From: John Hall [REDACTED]
Sent: 02 March 2019 10:11
To: Anita Gardner
Subject: F/30/18/PL - Wicks Farm, Ford

Please see the further comments below from the Civil Engineering Practice ref: Reservoir at Wicks Farm, Ford.

From: Martin Kempshall [REDACTED]
Sent: 01 March 2019 14:33
To: John Hall [REDACTED]
Cc: CEP | Reception [REDACTED] Steve Burgess [REDACTED]
Subject: 22979 - Wicks Farm, Ford

SECTION A-A: TYPICAL BERM CROSS-SECTION
(SCALE 1:50)

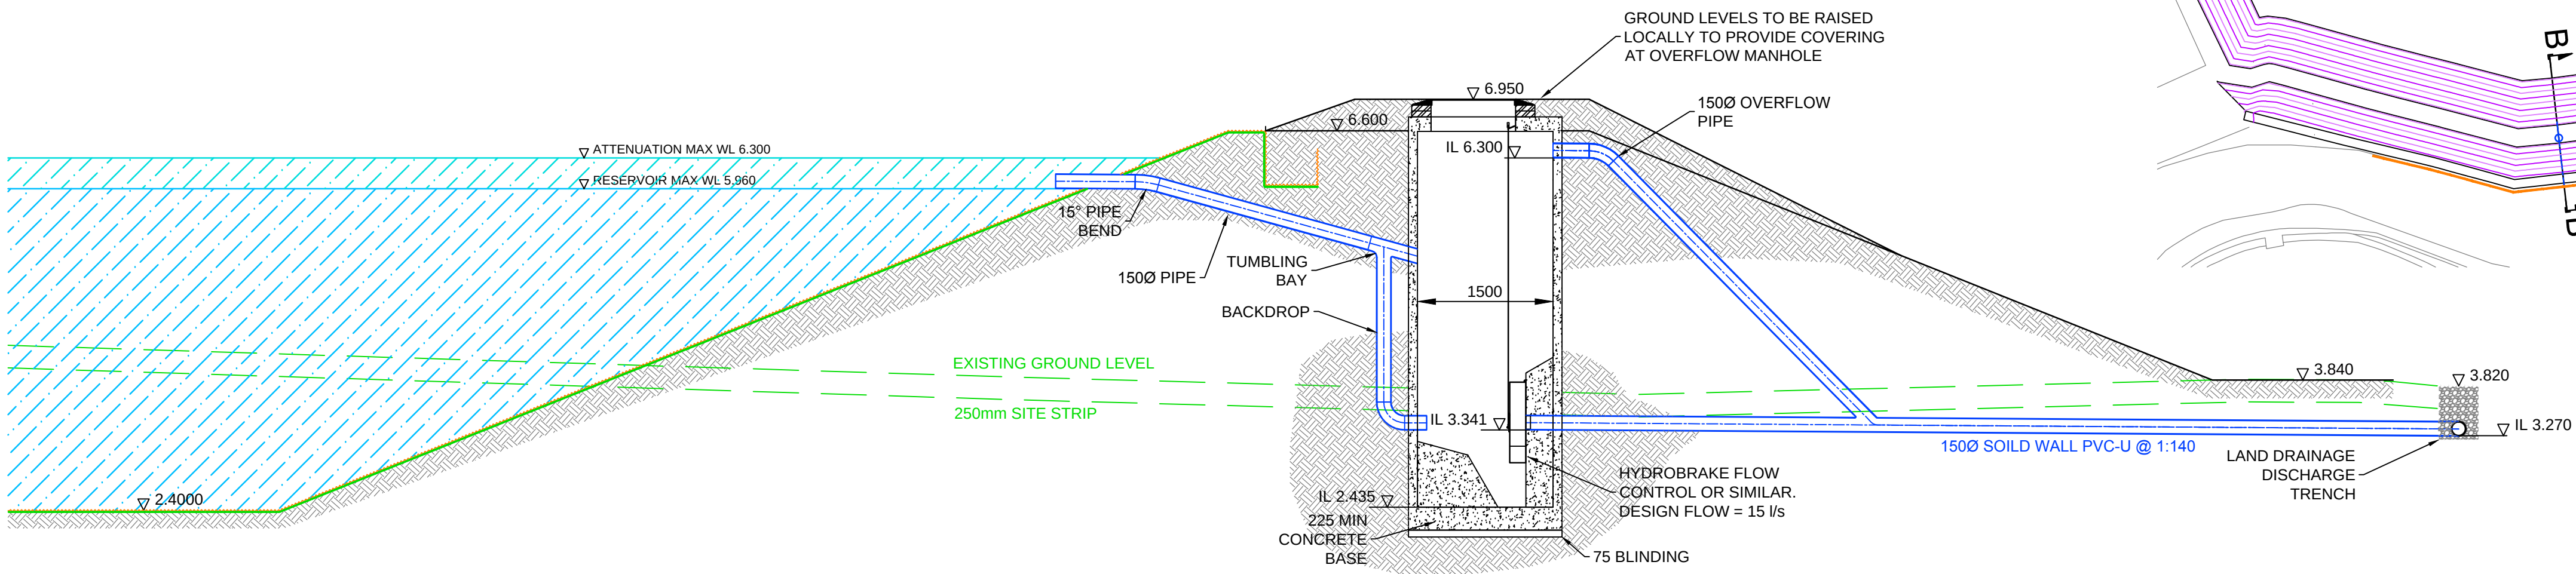
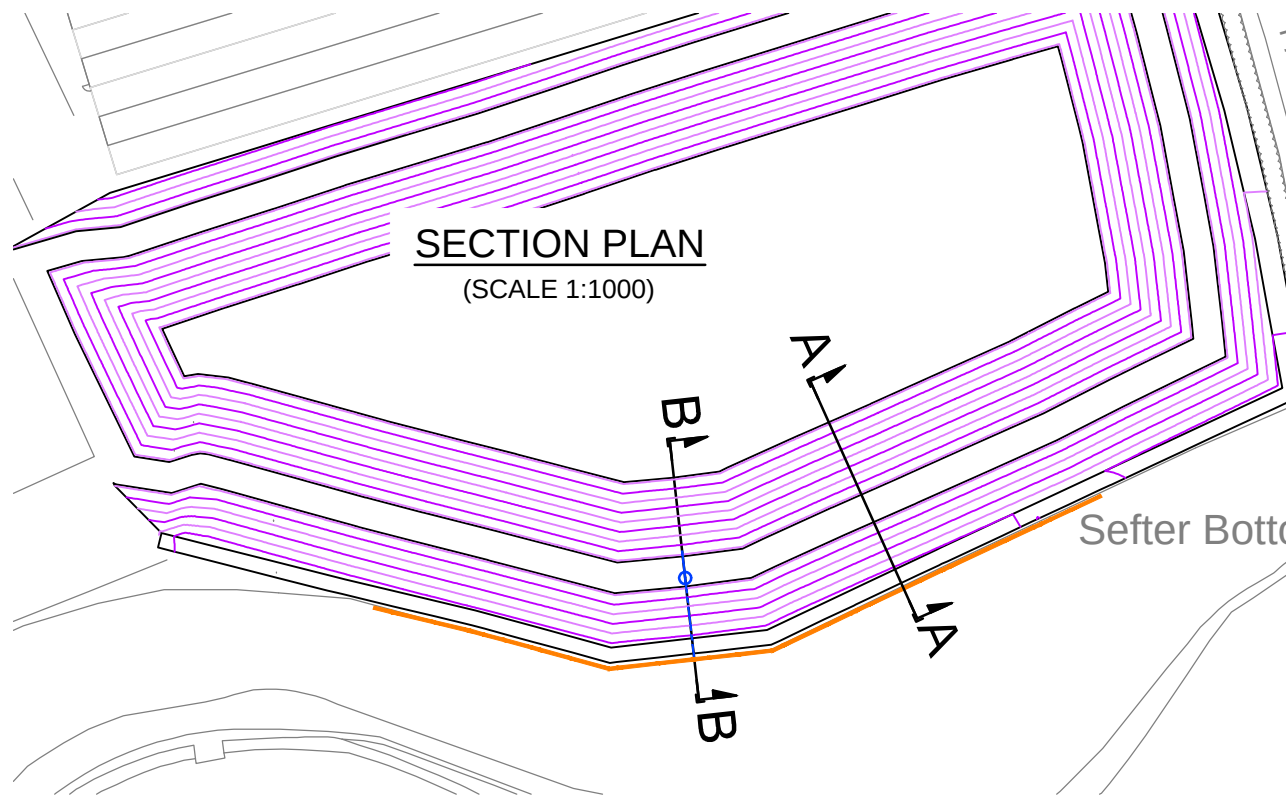
The request for infiltration to ground is based upon the SuDS hierarchy where this is always the first preference. However, I would argue this is inappropriate in this case as typically it would be preferential to lined the reservoir to maintain summer level during peak water usage, this can be proposed as part of the final design.

With regard to the comment on winter storage, winter irrigation usage could be considered within calculations as part of the detailed design to demonstrate that sufficient capacity could be maintained within the reservoir during the winter months. In the event that the reservoir was not capable of storing sufficient runoff for the design event during the winter months it could be demonstrated that any overland flow would follow existing land drainage flow paths. As a fall-back position, a mechanism or procedure could be in place to drawdown some of the lagoon to provide capacity before a forecasted major rainfall event.
